Your Ref: SSD-75493483

SD-75493483 – Environmental Impact Statement – Forest Lodge Integrated Seniors Living

1 EAST ELEVATION (ALONG JUNCTION ST)
SCALE 1 : 250

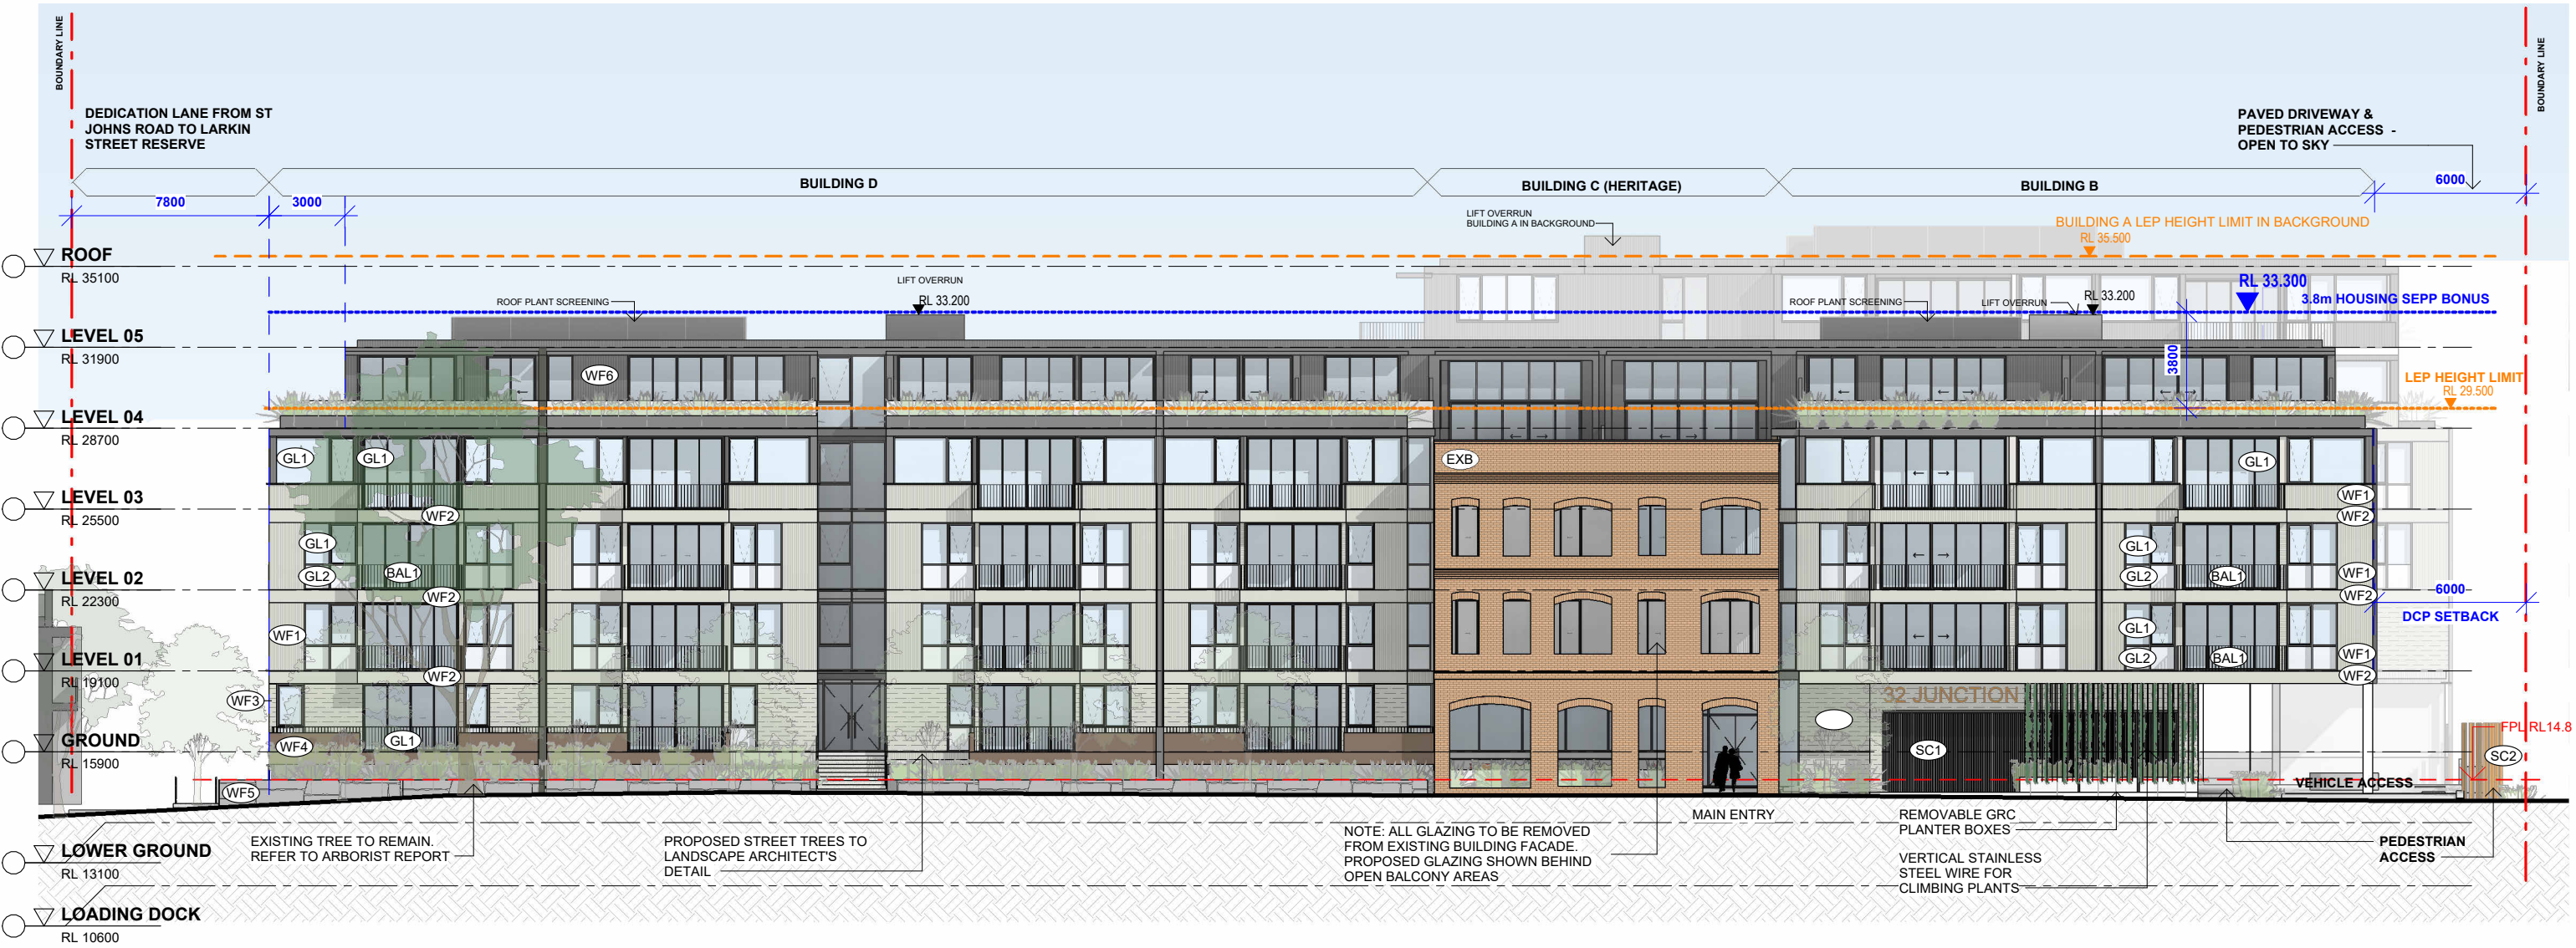
We object to the size of the development as it is out of proportion with Junction Street and the surrounding heritage conservation area.

The photomontage provided by the applicant is misleading as it is taken from a perspective that does not exist—houses would have to be demolished to get that angle—and the width of Junction Street significantly expanded (see Figure 10).

No photomontage is provided from ground level on the eastern side of Junction Street looking toward the proposed development in the Visual Assessment Report even though most of the terraces on the eastern side of Junction Street directly face the proposed development. From this angle it will be particularly imposing.

We request that the size of the proposed development be reduced, and an opening be introduced between the Heritage Building and one of the new buildings (B or D) to respect the general surrounding terrace typology (see Figure 11) to further reduce scale as suggested in 5.13 of the Seniors Design Guide. This would also allow the prevailing breezes to provide natural cooling in summer to the residents of Junction Street.
